Subject: Canal Mews Barnham

Regarding the proposed changes I've discussed with Maria, please see my last attached email to her before she went on leave. The plan in that email shows our most recent suggested revisions comprising 2 dwellings not 3 with plot 1 showing a 4.75m separation distance to the Root Protection Zone of the tree (now TPO'd). As I explained in the email, the tree and land around it will be retained as amenity space. The occupiers of the bungalows will pay an annual maintenance charge for the upkeep of the open space and tree. This will be enforced via the existing Lake Lane Management Co set up by Seawards for its nearby development in Lake Lane.

Drawing No. 02 - Tree Retention and Protection Plan
Land to the East of Barn Rise, Barnham

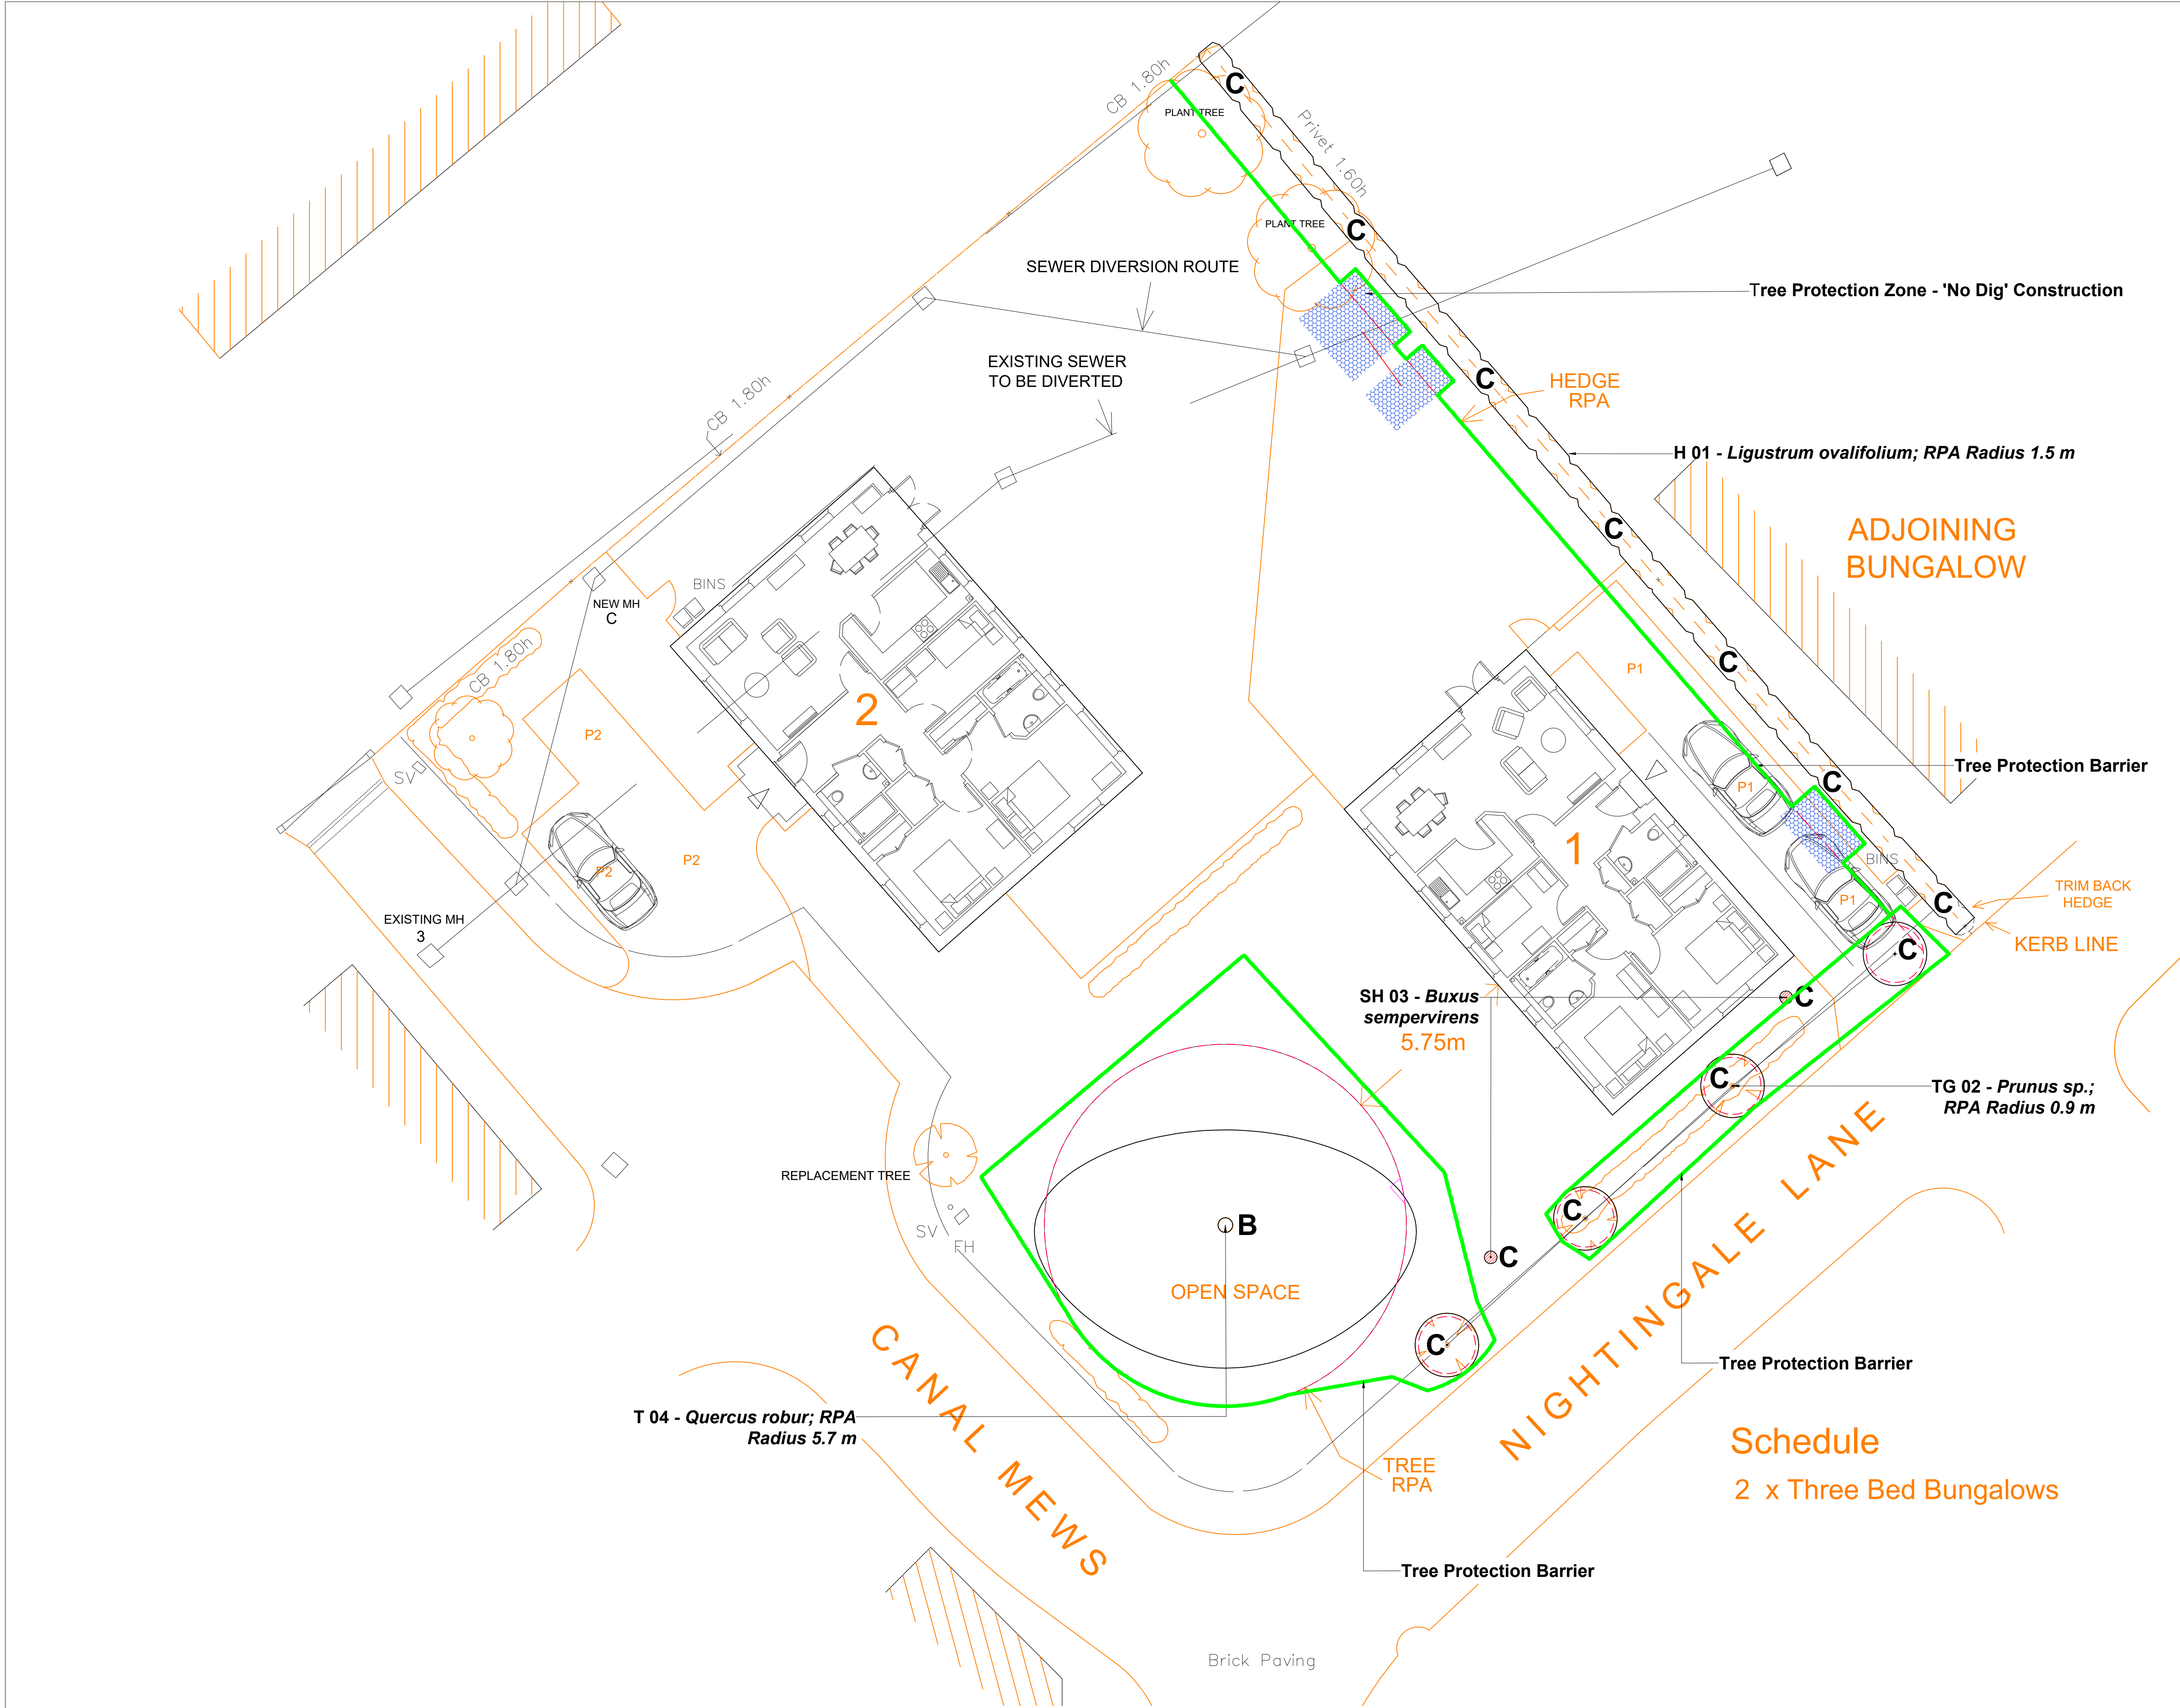
Mark Warwick had previously said in his 21 Jan email attached that he thought 3m between the existing tree canopy and house was too close and limits its potential for future growth. He thought an extra 2-3m clearance would be

adequate. As we now show 4.75m to the RPZ plus extra to the tree canopy we now comply with Marks requirements. I'd add that we sought independent advice from an arborist in making the changes and I've reproduced the comment below for you and Mark (the TPO has of course already been imposed):

The proposals provide both an entirely protected RPA, another 4.75m for the root area to increase significantly, as v
Both houses would be subject to some minor shading, leaf litter etc. but given the distances and size of the tree this
the existing road.
